From: Amanda Scholes on behalf of Planning.Responses
Sent: 04 August 2020 12:10
To: Planning Scanning
Subject: FW: A/86/20/DOC - Manor Nurseries, High Street, Angmering

From: Kate Giddings <kate.giddings@arun.gov.uk>
Sent: 04 August 2020 10:55
To: Michael Eastham <Michael.Eastham@arun.gov.uk>
Cc: Planning.Responses <Planning.Responses@arun.gov.uk>
Subject: RE: A/86/20/DOC - Manor Nurseries, High Street, Angmering

Please could I have your consultation response to **Condition 10 (Construction Management Plan)** and **Condition 24 (Contamination)** of discharge of condition application **A/86/20/DOC** regarding Manor Nurseries, High Street, Angmering by the close of play today (**Tuesday 4th August 2020**)?

Plant room on the east of the site.

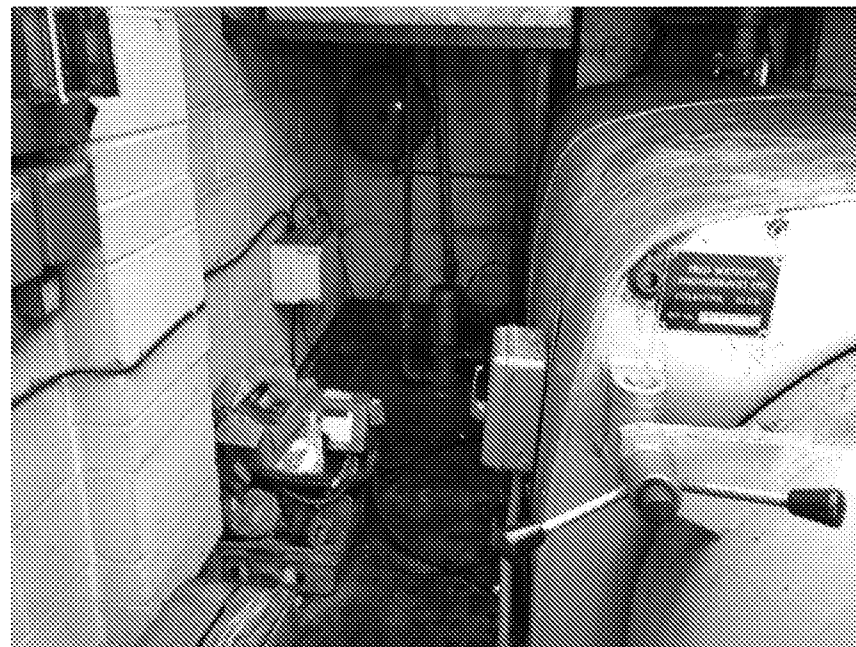
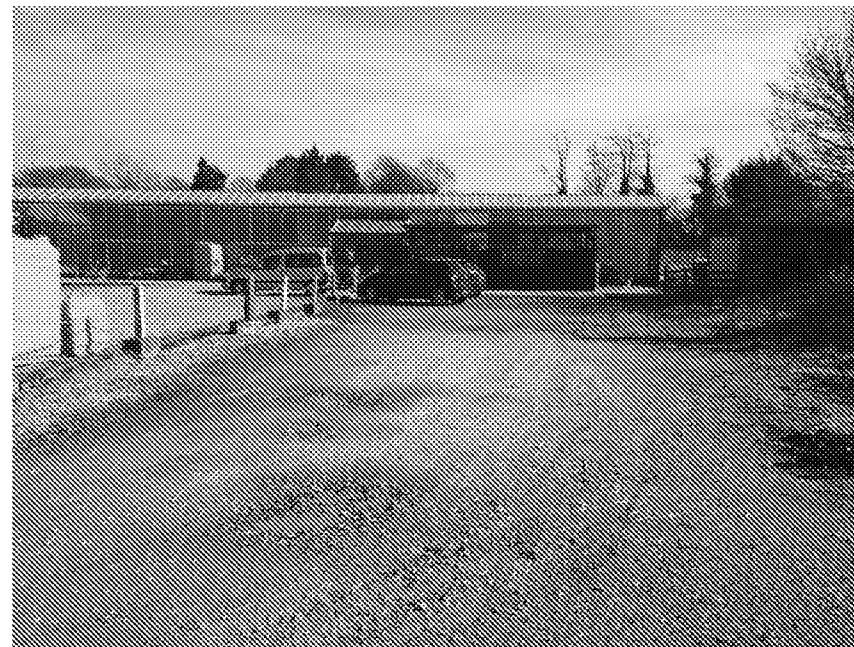
Condition 24 (CL) – the majority of Ashdown Site Investigation Limited's Revised Ground Contamination Risk assessment Report (ref.: R14233 for project P14618, dated May 2020) is acceptable. The removal of the asbestos roof from the plant room is noted, however there is no information regarding when this is likely to have occurred, how the roof was removed nor where it went.

With reference to discharging the condition, it is not possible to recommend a complete discharge at this stage, although EH is satisfied that works may commence. If you are willing to accept a partial discharge, parts 1-3 could be approved with part 4 (including a watching brief) to be demonstrated upon completion of the groundworks.
